Recommendation Report

EG/15/13

Re: 20 Gospond Road, Barnham – Ref: EG/15/13

Planning Application EG/15/13 20 Gospond Road, Barnham **Dropped kerb and driveway to front**

Drg No.: 6714/01A

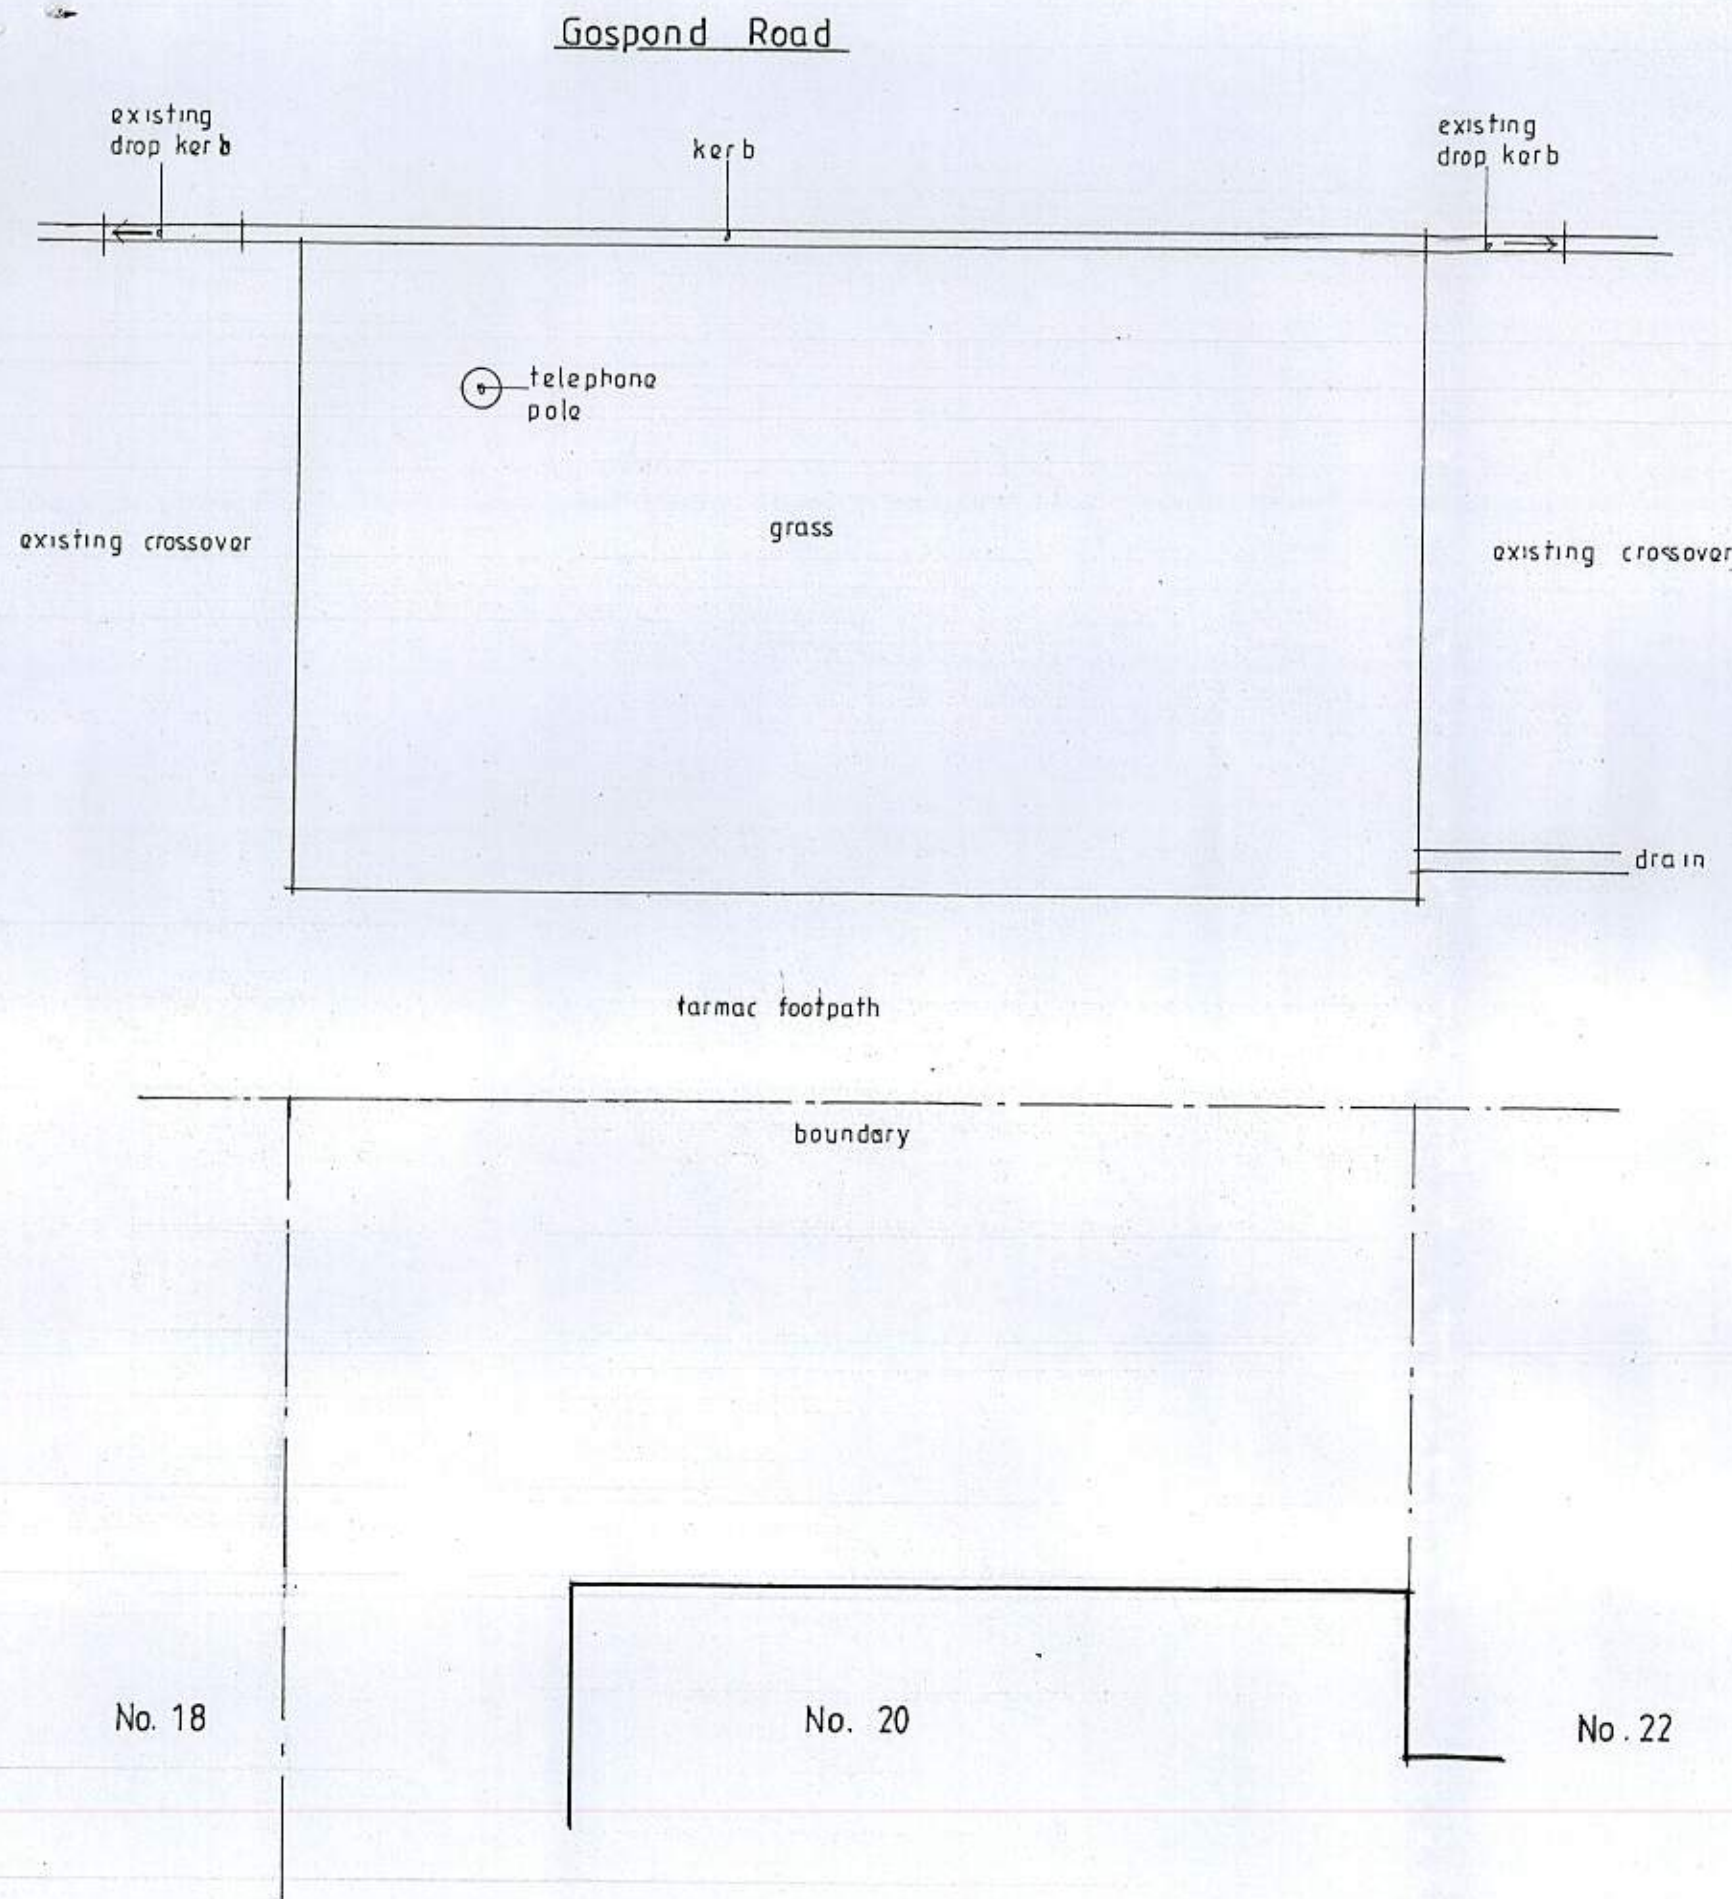
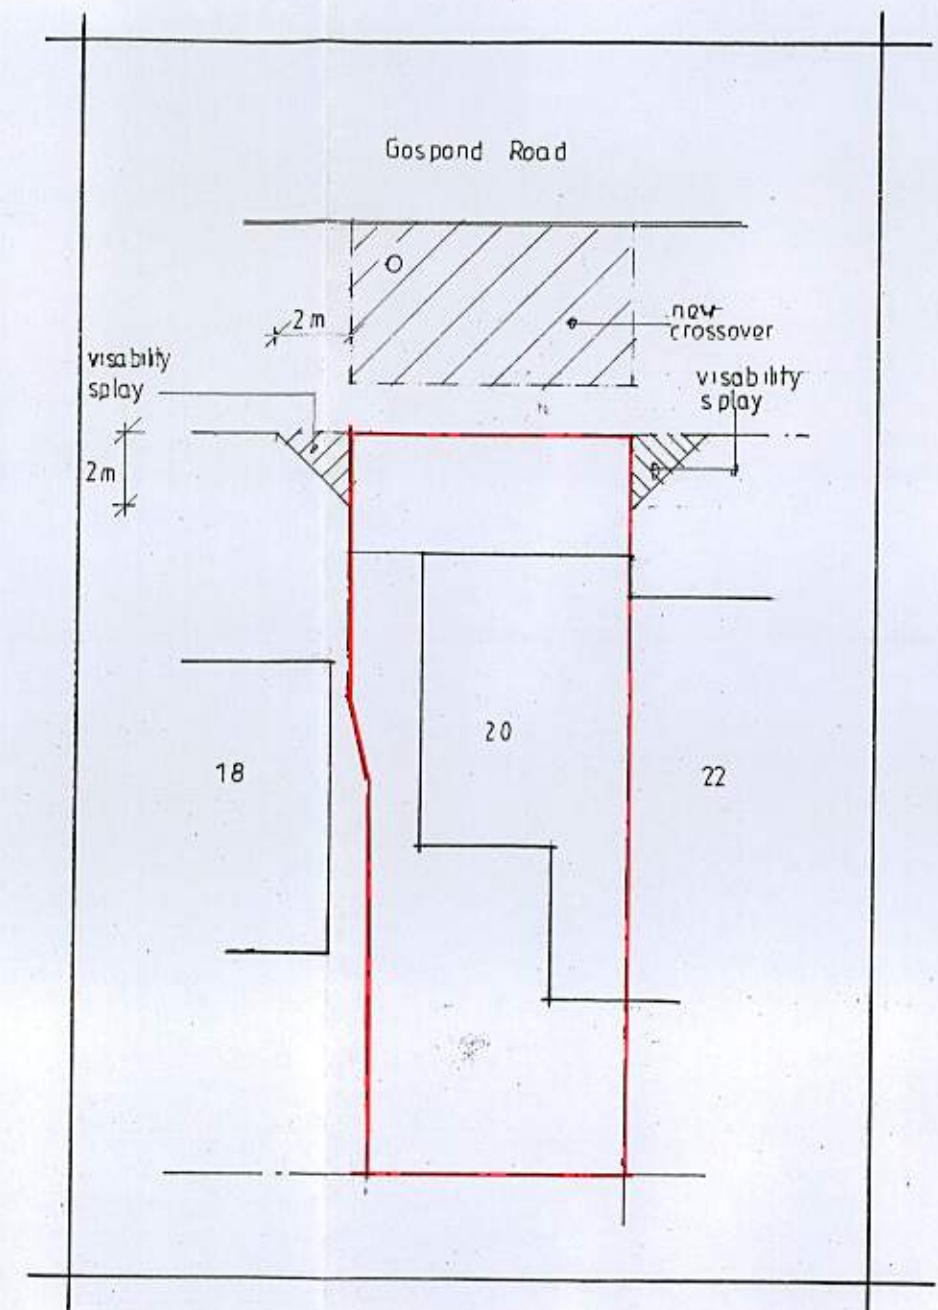
"From inspection of the plans and information available it would appear the intention is for a vehicle to be parked on the property's frontage. This looks to be quite tight for a vehicle to be parked there without obstructing the footway that abuts the property boundary.

WSCC will require further information on a plan as to where it is intended vehicles to be parked on the driveway".

As requested please find enclosed three copies of Drawing No. 6714/03 showing the proposed onsite parking arrangements.
